17 December, 2010

Our ref : ER21325
Your ref: MP10_0007 (Mod 2)

**MP10_0007 MOD 2 and MP10_0008 MOD 2– Len Waters Industrial Estate (Former Hoxton Park Aerodrome) - Section 75W Modification – Basin 6 modification
Environmental Assessment – Liverpool Local Government Area**

**Figure 12** – Proposed basin location

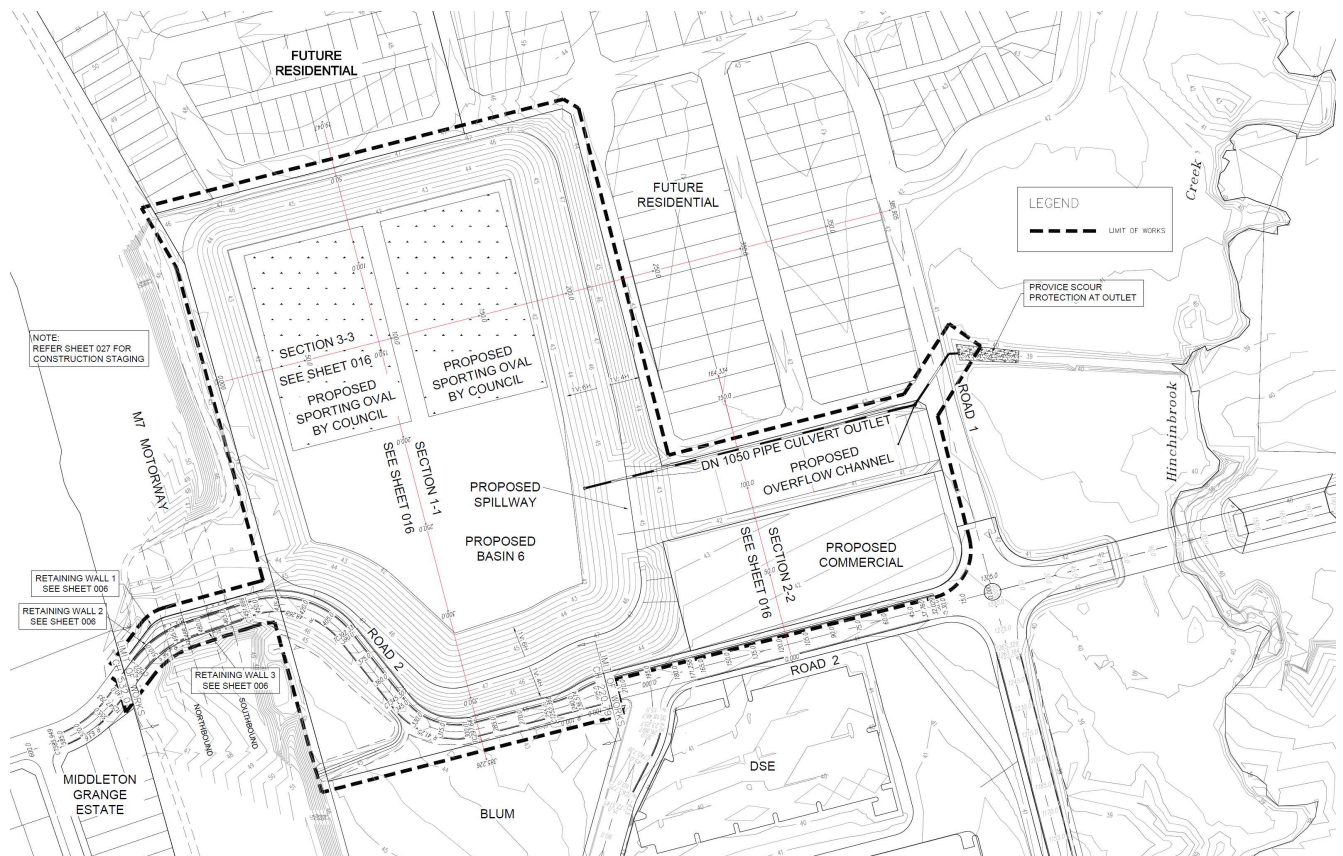
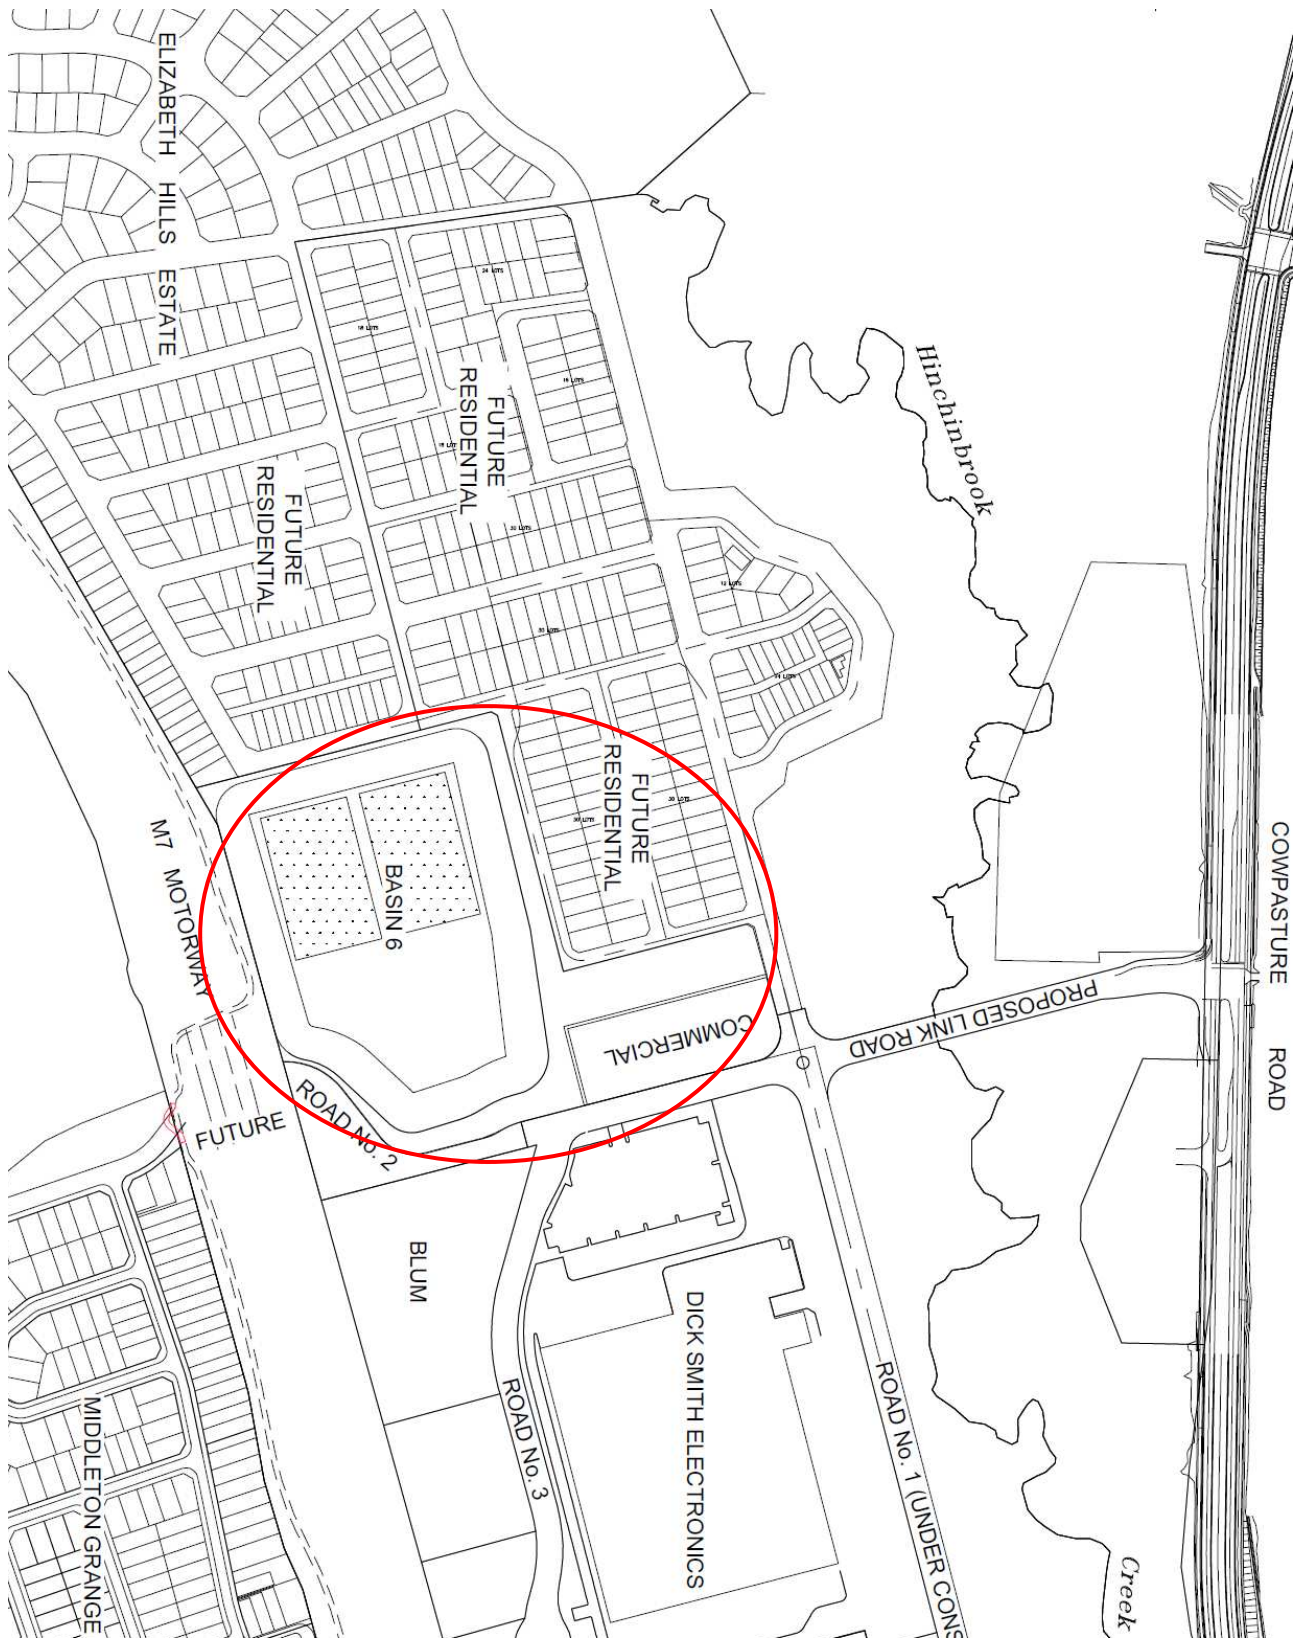
The Office does not support the proposed location for the northern basin (Basin 6) and recommends the Modification Application not be approved. The proposed location of Basin 6 will impact on the establishment of a naturalised functioning creek system and environmental corridor that is meant to be established to link the Western Sydney Regional Park across to Hinchinbrook Creek. The corridor linkage is meant to be provided via the Northern Creek on the Middleton Grange site and continue through the Hoxton Park Aerodrome site.

Section 5.7 of Appendix C indicates a vegetation link /riparian corridor was originally proposed in the vicinity of Basin 6 to link Hinchinbrook Creek to the Western Sydney Parklands. It notes the construction of Basin 6 and the necessity to incorporate a highly restricted outlet configuration diminishes the ability to maintain a continuous vegetation/riparian corridor. The Office recommends the basin not be constructed where it diminishes the ability to maintain a continuous vegetation/riparian corridor.
